Cambridgeshire County Council and Fenland District Council

Application by Medworth CHP Limited for an Order Granting Development Consent
for the Medworth Energy from Waste Combined Heat and Power Facility

Planning Inspectorate Reference: EN010110

Written Representation

**Figure 10.1i**  
**New Bridge Lane access design**

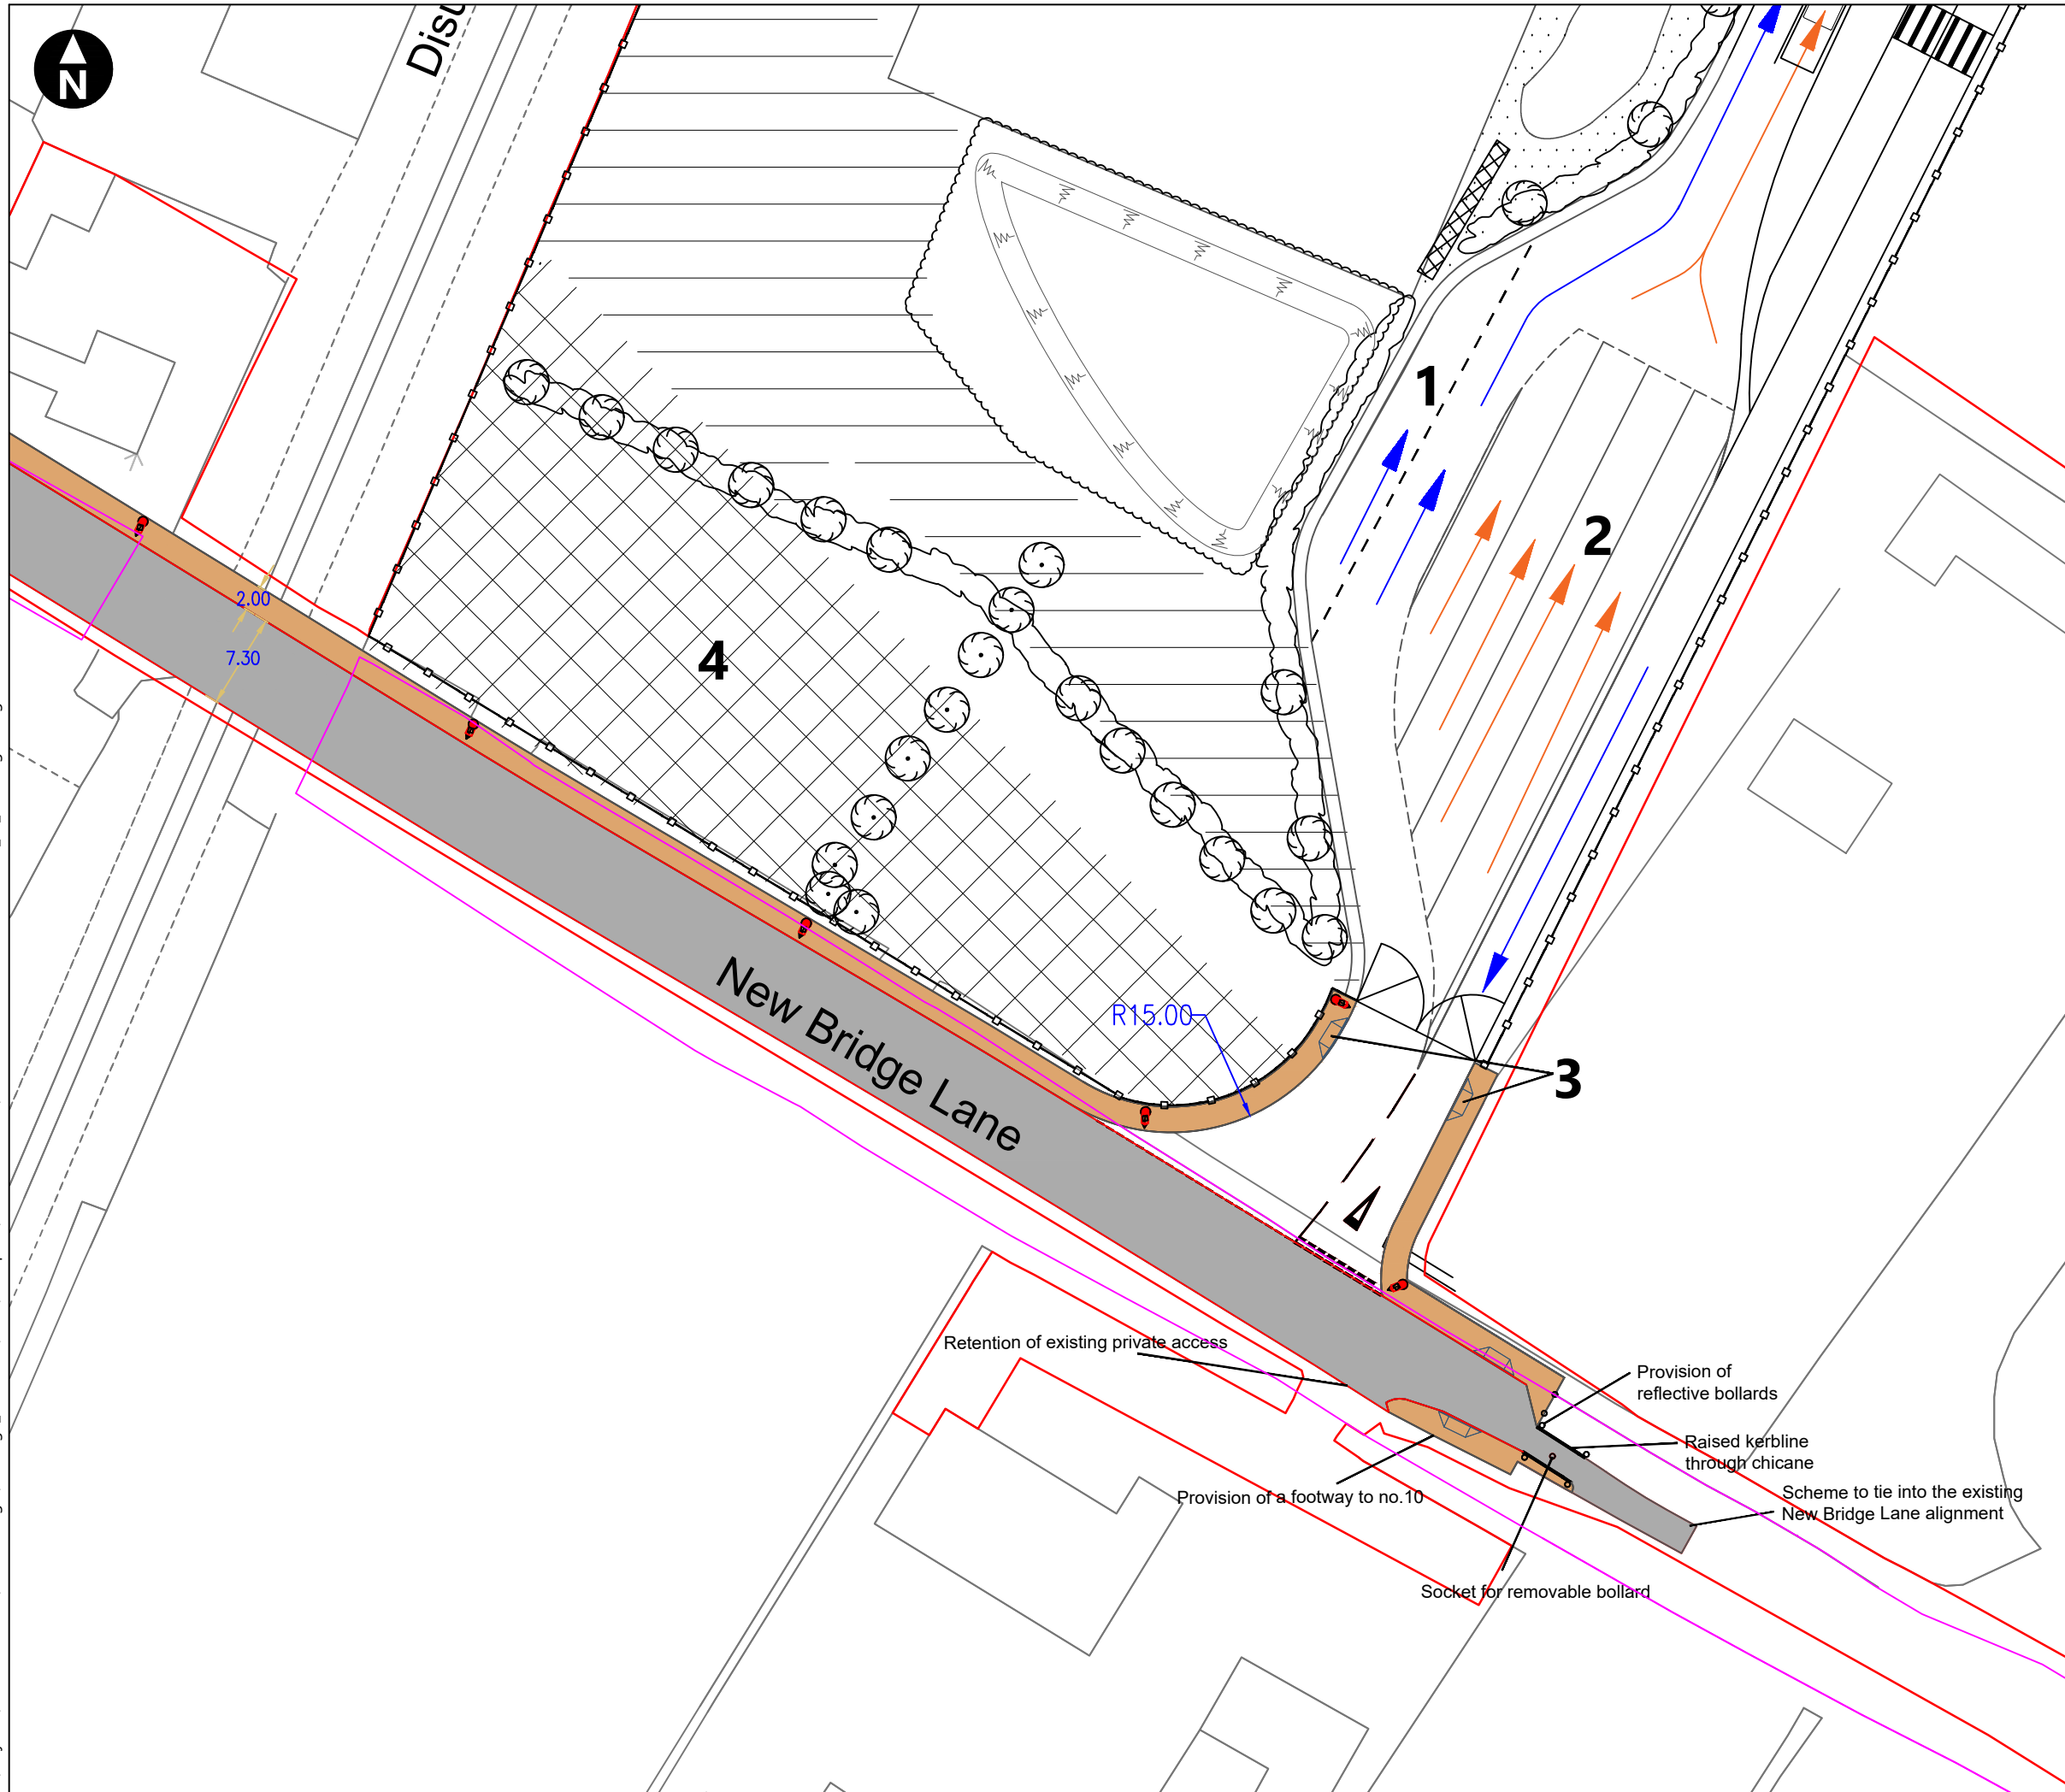
- 5.9 The Councils have provided comment and evidence that there is insufficient land available along New Bridge Lane to achieve a wide enough access road for the facility, as stated in 2.7.19 of the LIR. The new proposed carriageway construction is shown in close proximity to the adjacent drain. The Internal Drainage Board and Local Highways Authority have highlighted that watercourse embankments/culverts along New Bridge Lane would need to be altered significantly in order to provide the necessary stability and protection of the adjacent carriageway as well as to protect the watercourse asset. Failure to consider the full extent of the land take required for the new carriageway and then design amendments accordingly, would result in the proposed works not being achievable. If the access road cannot be constructed with

sufficient width and support, then this could result in safety issues that could impact the residents and businesses in the area.

**Figure 10.1iv**  
**Cromwell Road/New Bridge Lane Signal Scheme - General arrangement**

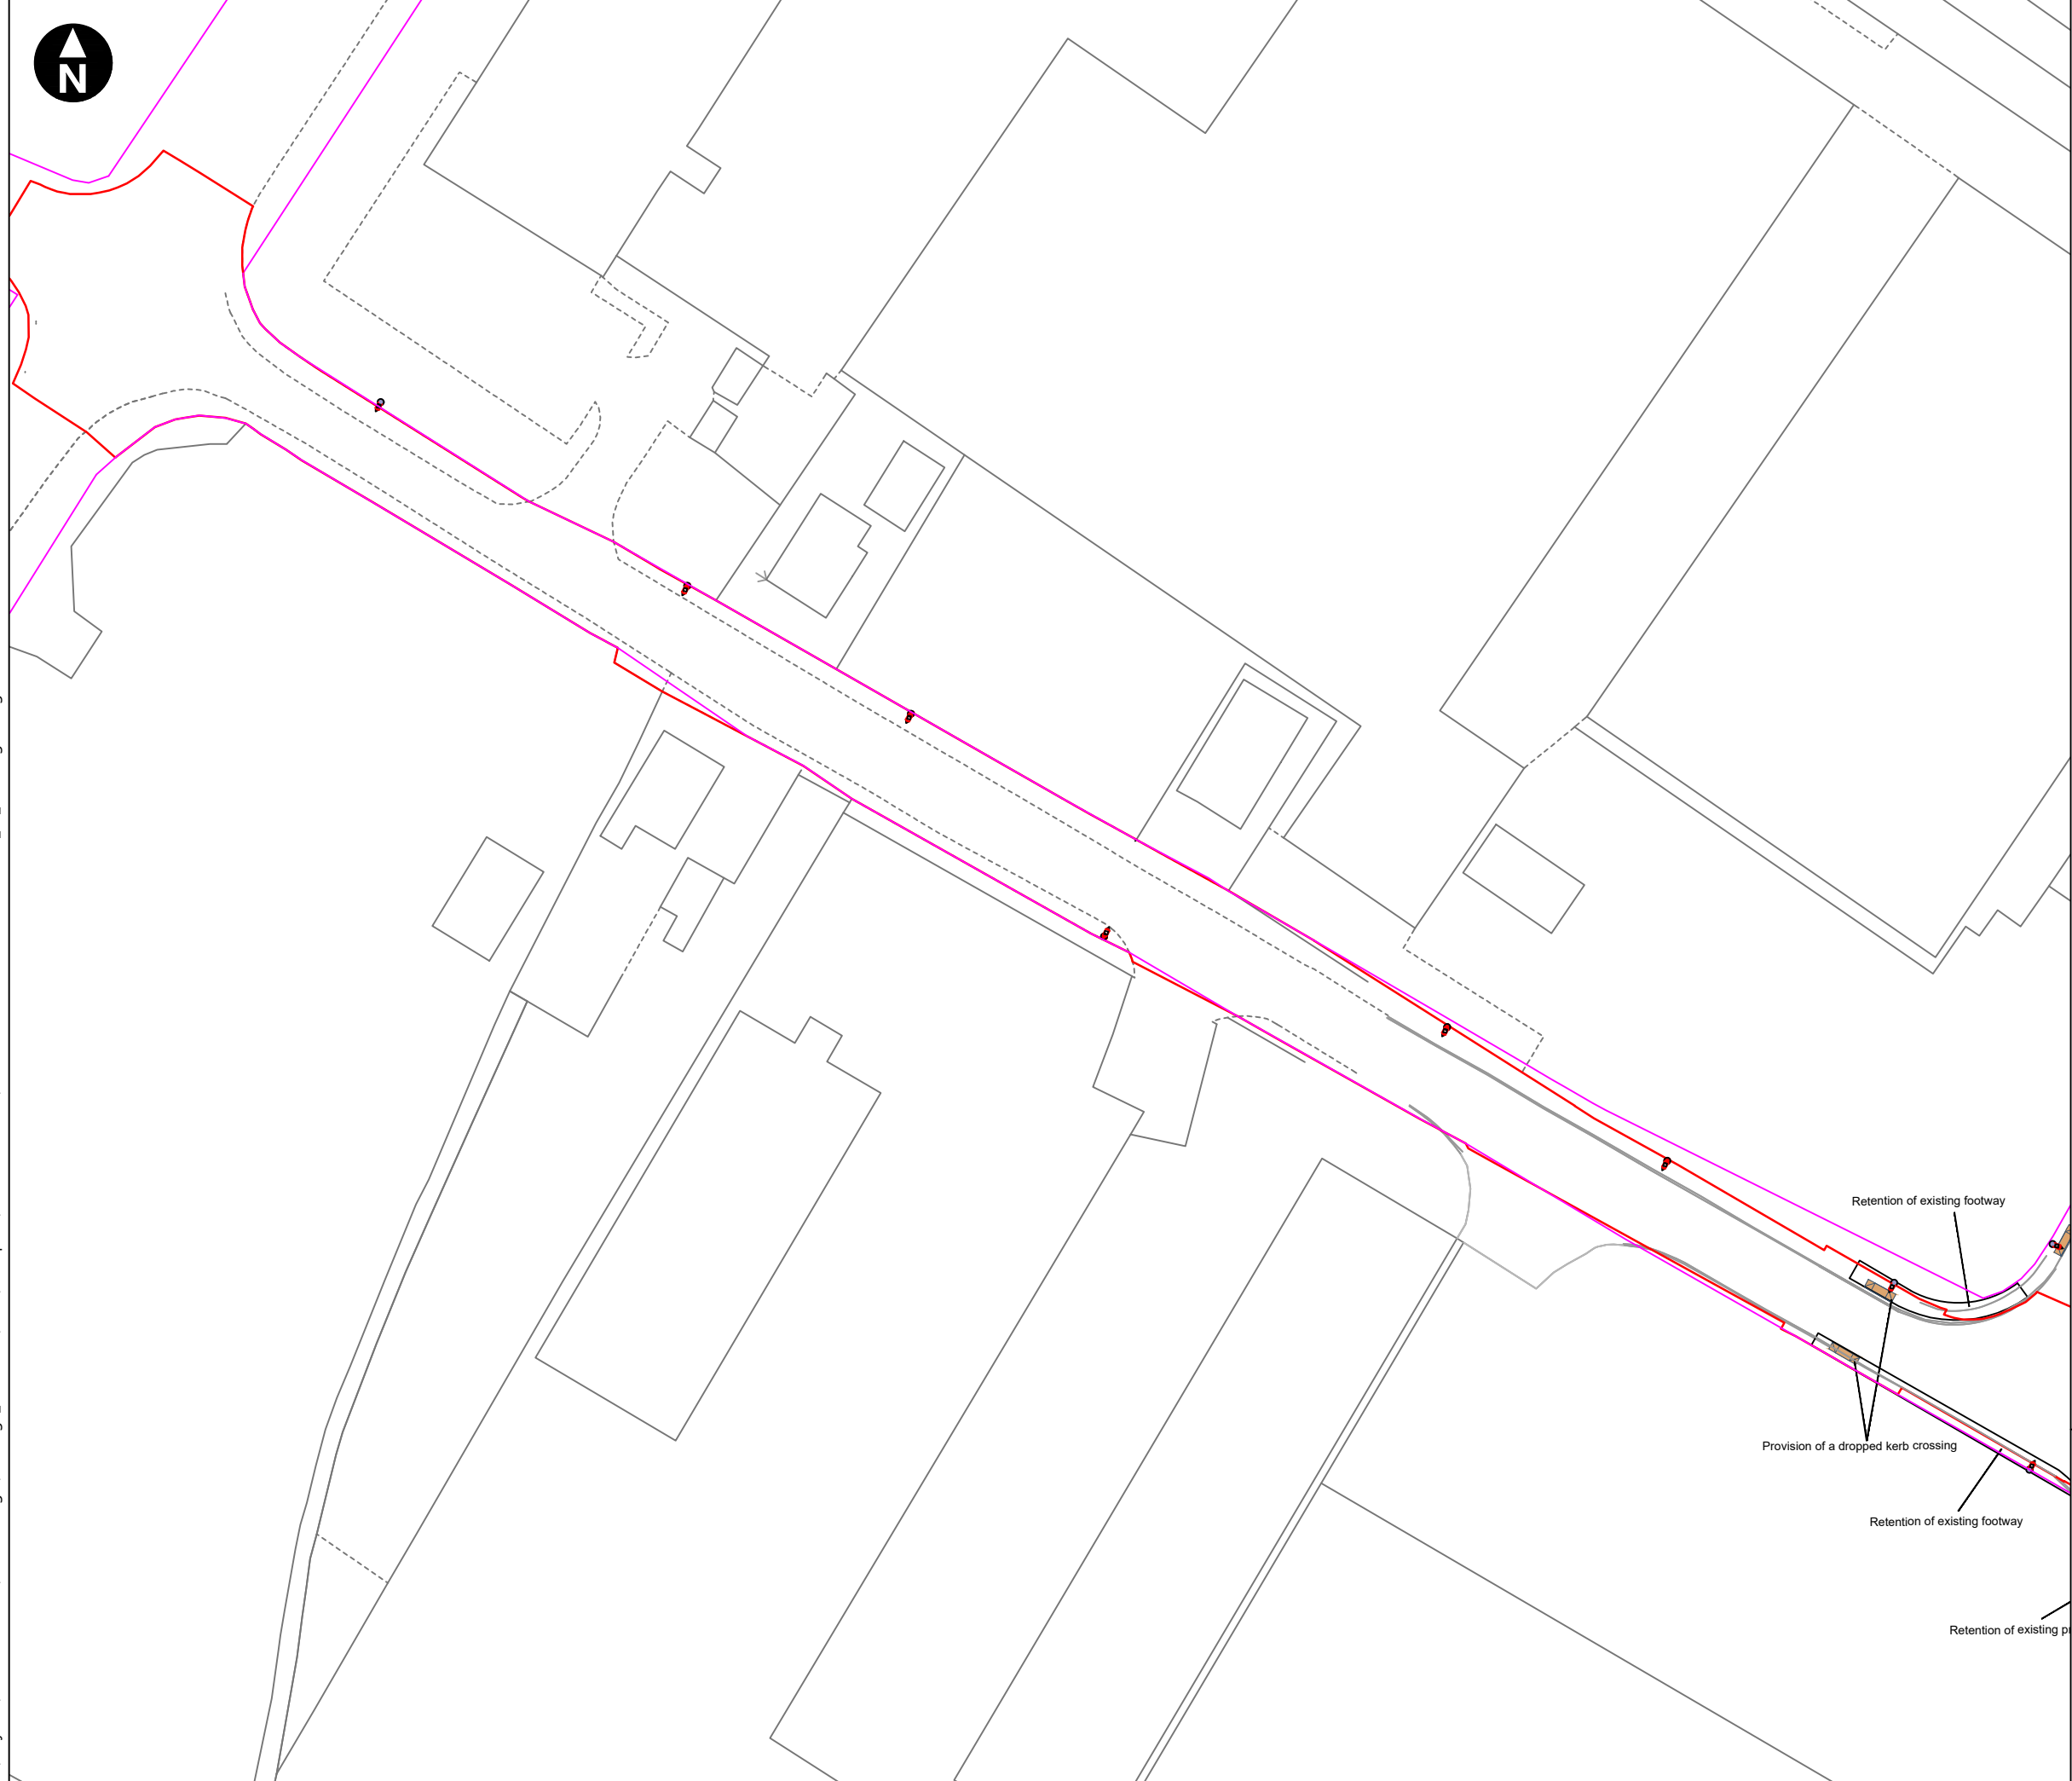
- 6.1 The impact of the proposed development on the Cromwell Road/New Bridge Lane Junction is a key area of concern.
- 6.2 If development consent is granted, improvements to the junction in the form of signal control would be necessary. However, CCC's Signals and Safety Audit Team consider that an acceptable form of junction design may not be achievable within the existing highways constraints. The consequence of this junction not being properly

signalised would be that the principal access to the scheme would be unsafe and therefore the proposal itself would be unacceptable.

- 6.3 The Councils are of the view that the existing junction arrangement is simply not suitable to cater for the additional construction, operational and decommissioning traffic that the proposed facility would generate. The large volume of slow-moving HGVs turning right from Cromwell Road into New Bride Lane that would be associated with the development during each phase raises serious safety concerns.
